WEST SUSSEX COUNTY COUNCIL CONSULTATION

TO:	Arun District Council FAO:Mrs A Gardner
FROM:	WSCC - Highways Authority
DATE:	18 March 2020
LOCATION:	Look & Sea Centre 61-63 Surrey Street Littlehampton BN17 5AW
SUBJECT:	LU/51/20/PL Change of use of upper 2 floors from the existing mixed use to 6 No. suites for tourist accommodation (C1 Hotels). This application may affect the setting of a listed building & may affect the character & appearance of the Littlehampton (River Road) Conservation Area.
DATE OF SITE VISIT:	n/a
RECOMMENDATION:	No Objection
S106 CONTRIBUTION TOTAL:	n/a

DRAWING TITLE
Location plan, block plan and site plan

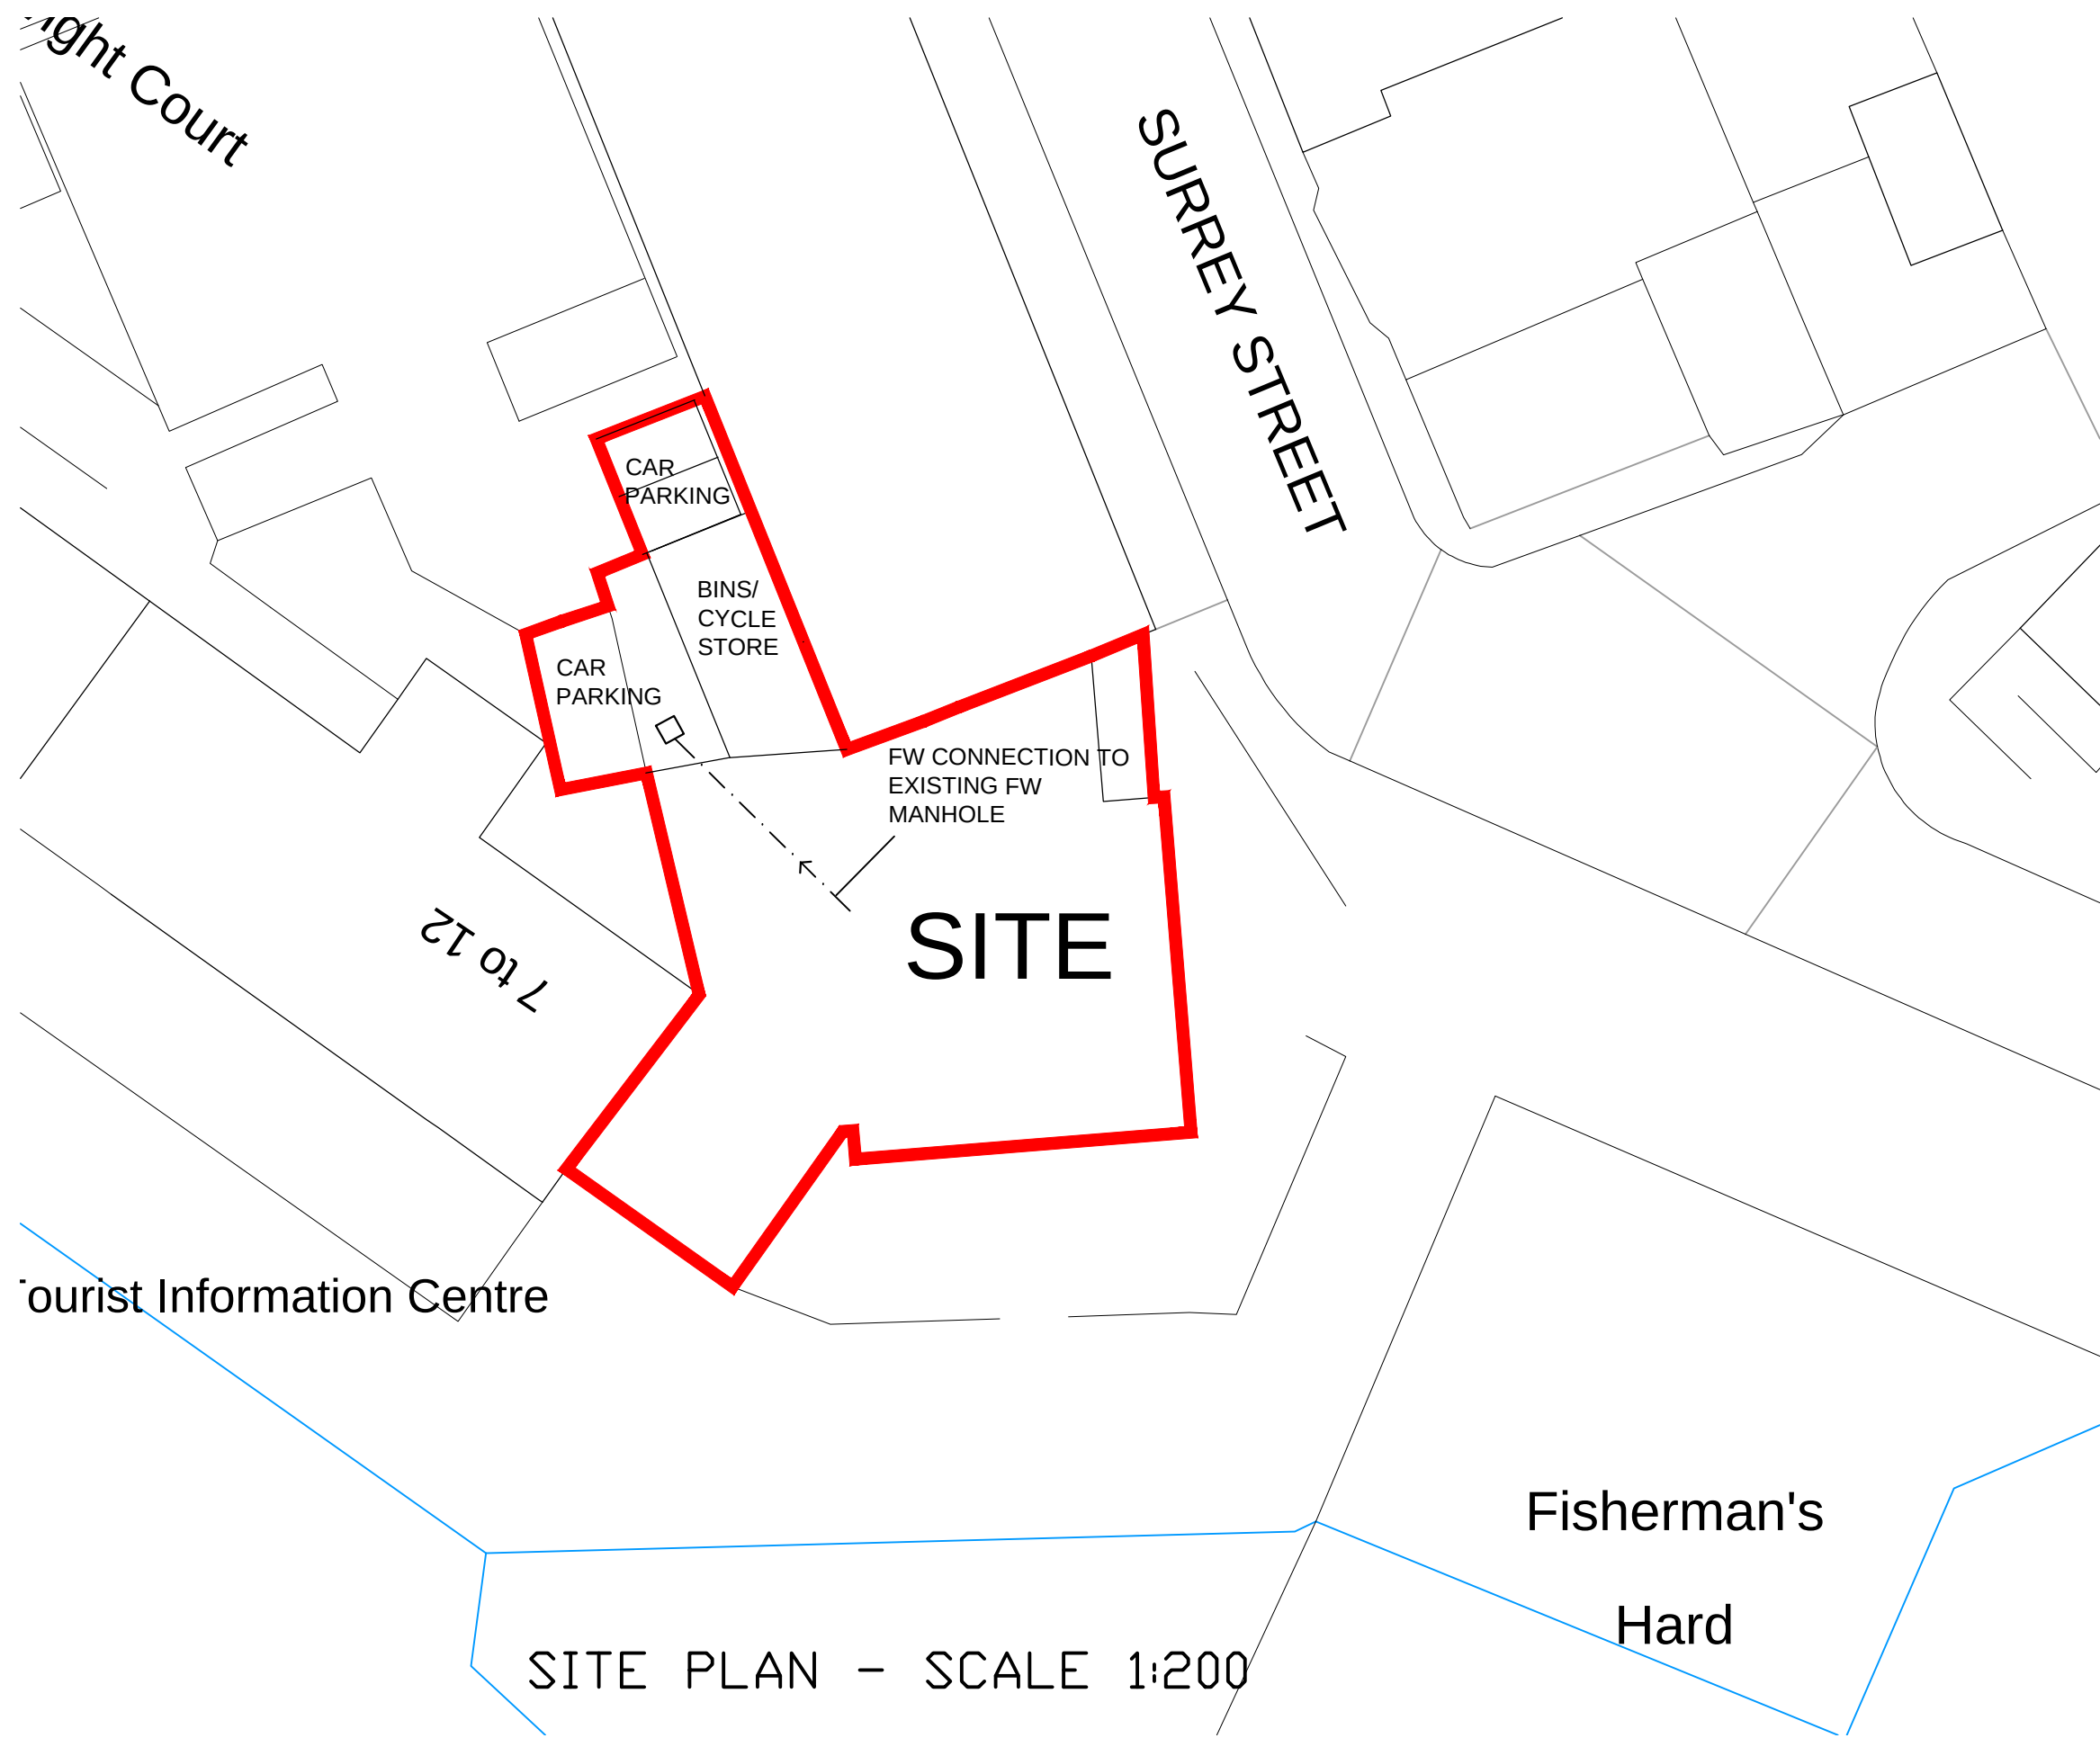
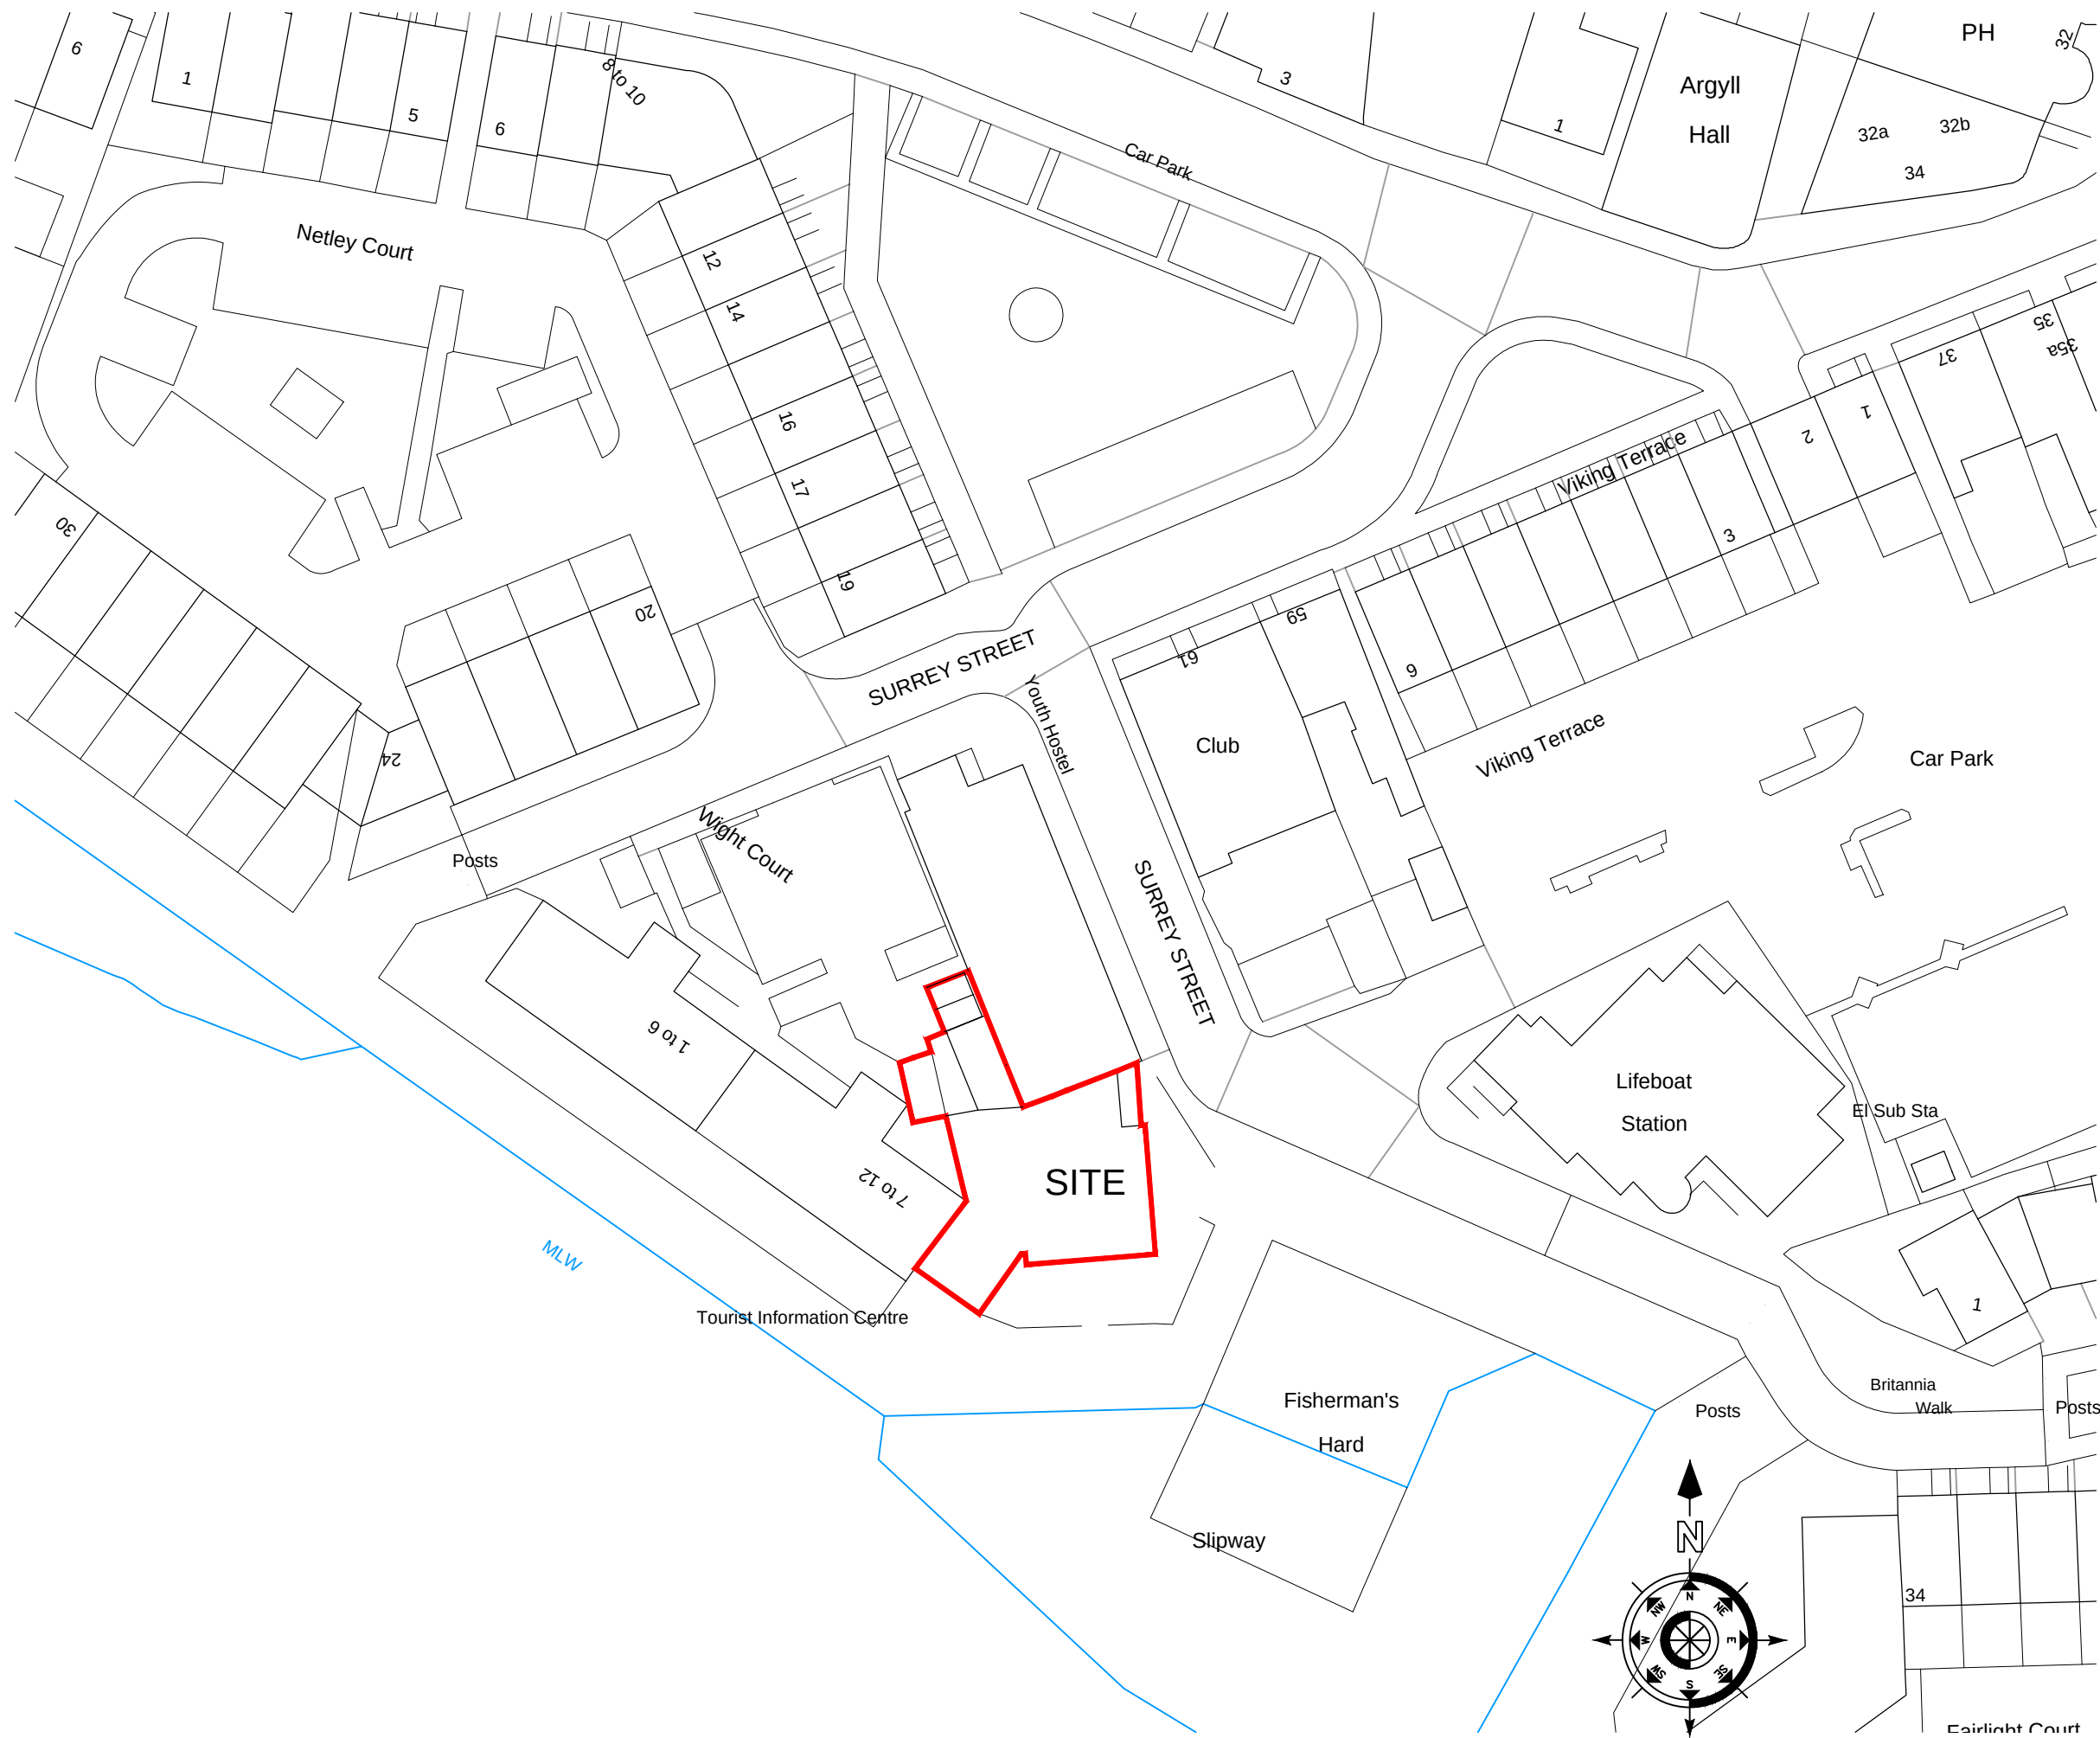
3 parking spaces are existing and proposed, whilst this may fall short for the proposed 6 suites, there is public parking within meters of the site. There are also sustainable travel options available. The highway in this location is also protected in terms of highway safety with double yellow lines to stop any parking in undesired locations.
